### **Crystal Park Site S-93, CP-18-010**

**Please accept the following comments from El Paso County Public Health regarding the project referenced above:**

2 SP1 SITE PLAN
 SCALE: 1" = 10'-0"

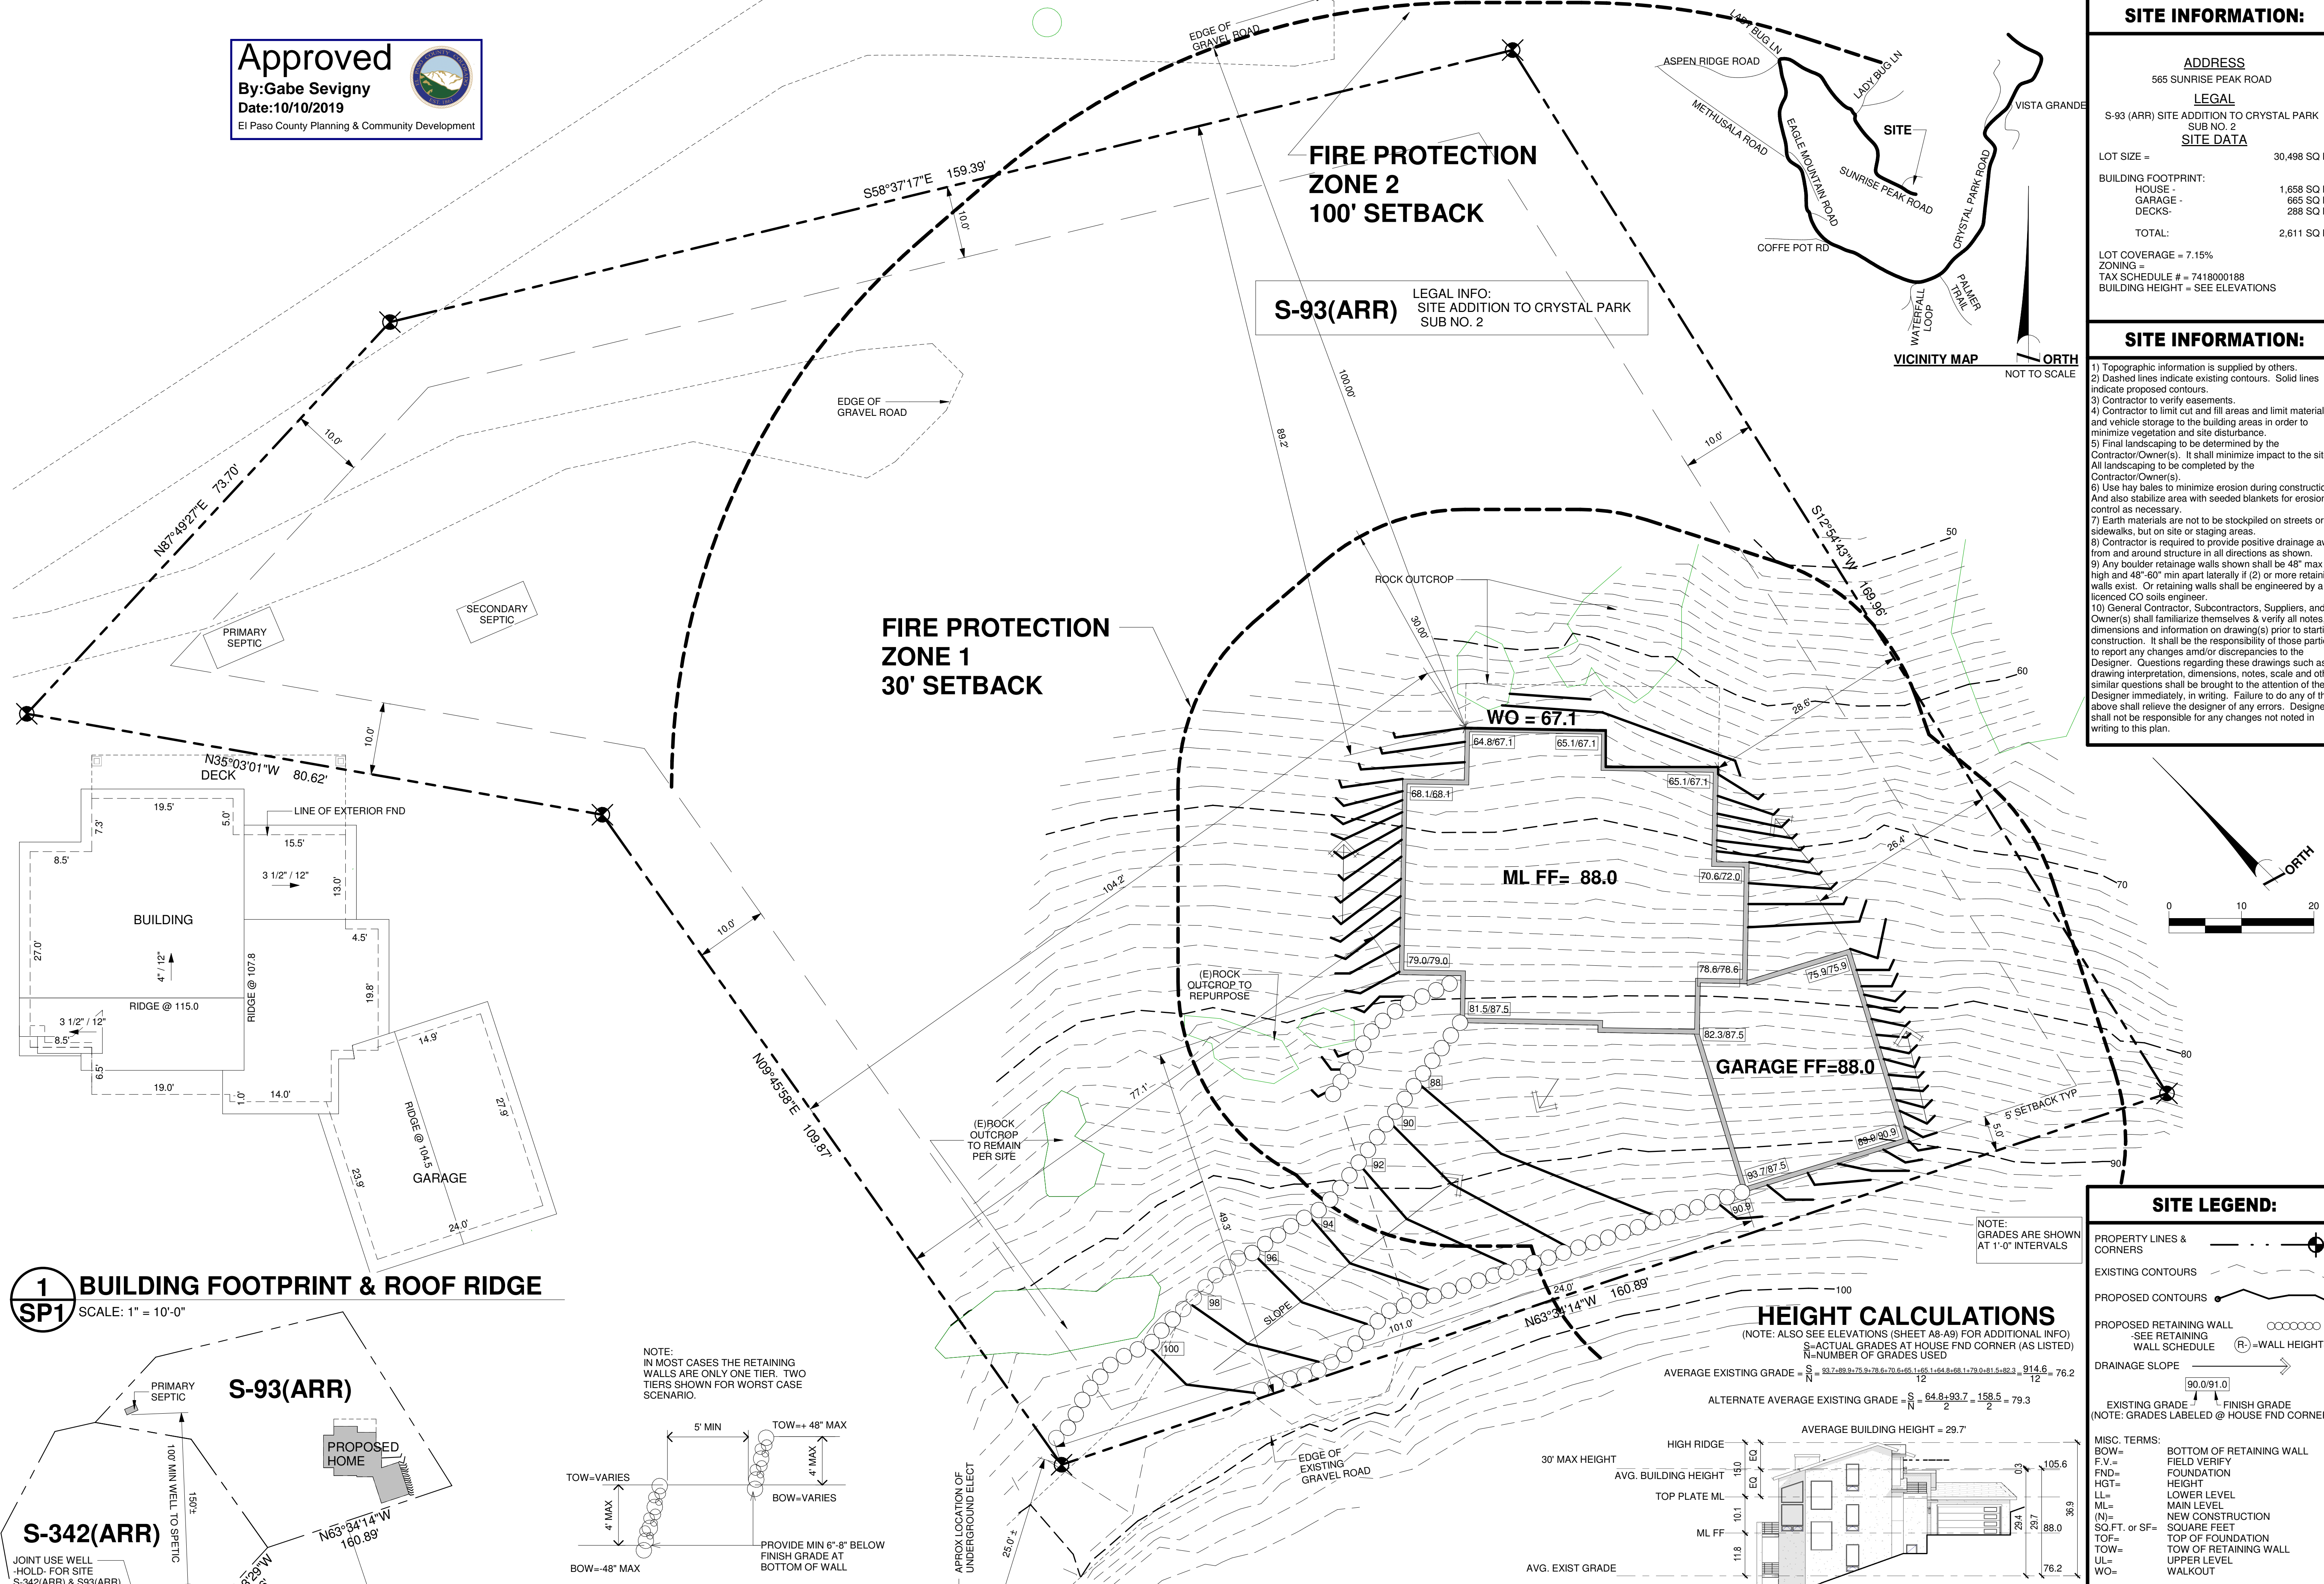
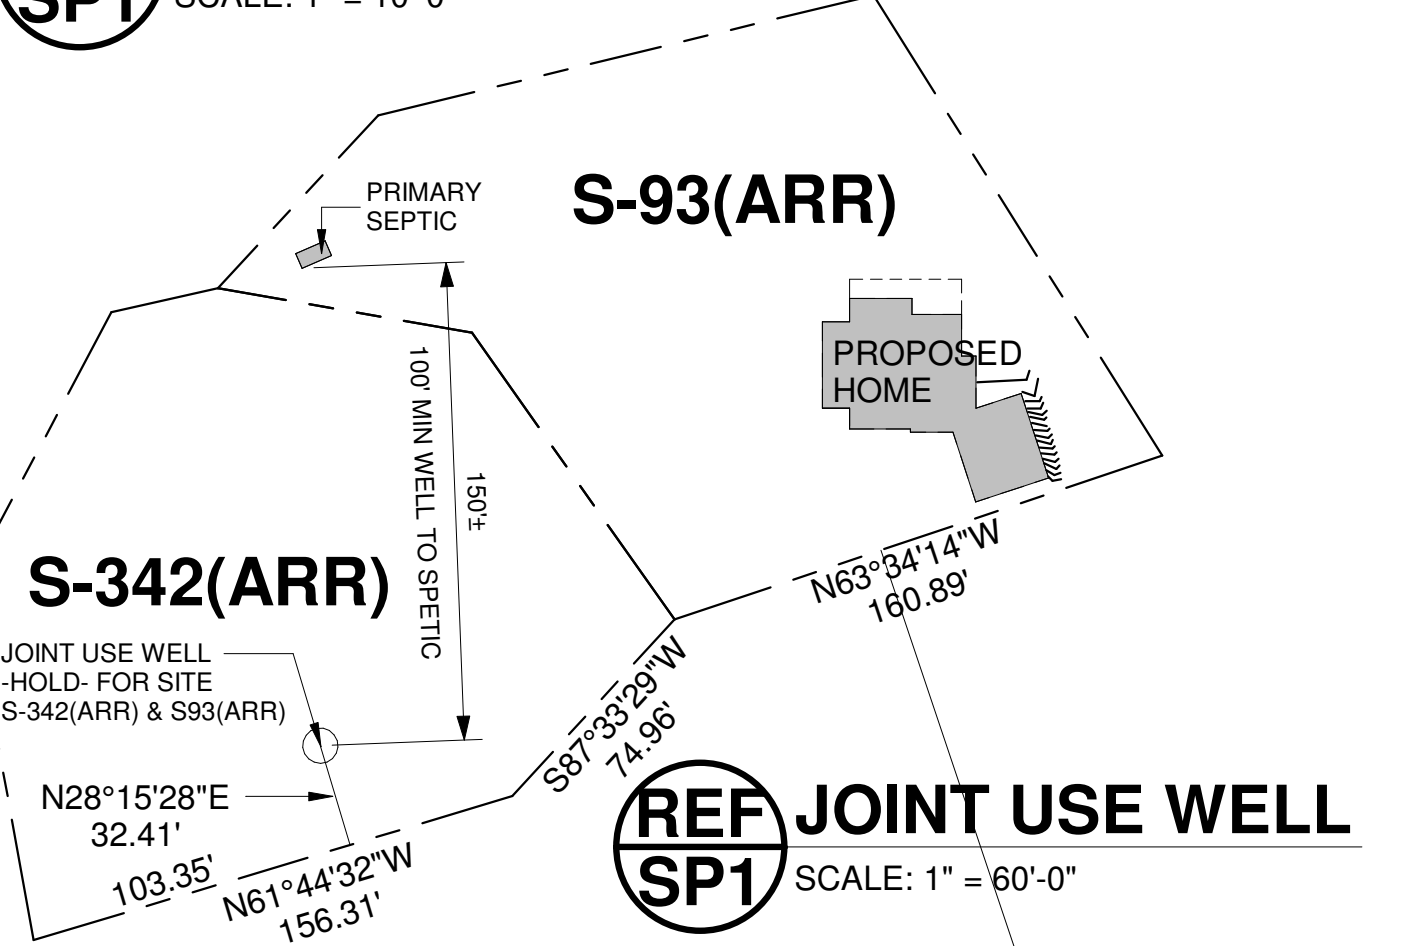
- **The site development plan indicates areas for both a primary soil treatment area (STA) site and an alternate STA. The OWTS must meet all current El Paso County Public Health OWTS Regulations. Please be aware that a vertical STA or “seepage pit or drywell” is the last type of STA to be considered for approval. The results of the soil test in these areas will determine the types of STA’s to be considered for approval.**

- **The STA’s must be 100’ minimum from any well, internal or external, and also must be protected from all house construction and site development activities. Compaction of the STA by such activities may cause the area to be unsuitable for use. Recommend fencing the area during construction to minimize the potential for soil compaction. Adjacent property well locations were not shown on the Site Plan; therefore, be aware of the specific 100’ setback requirements.**
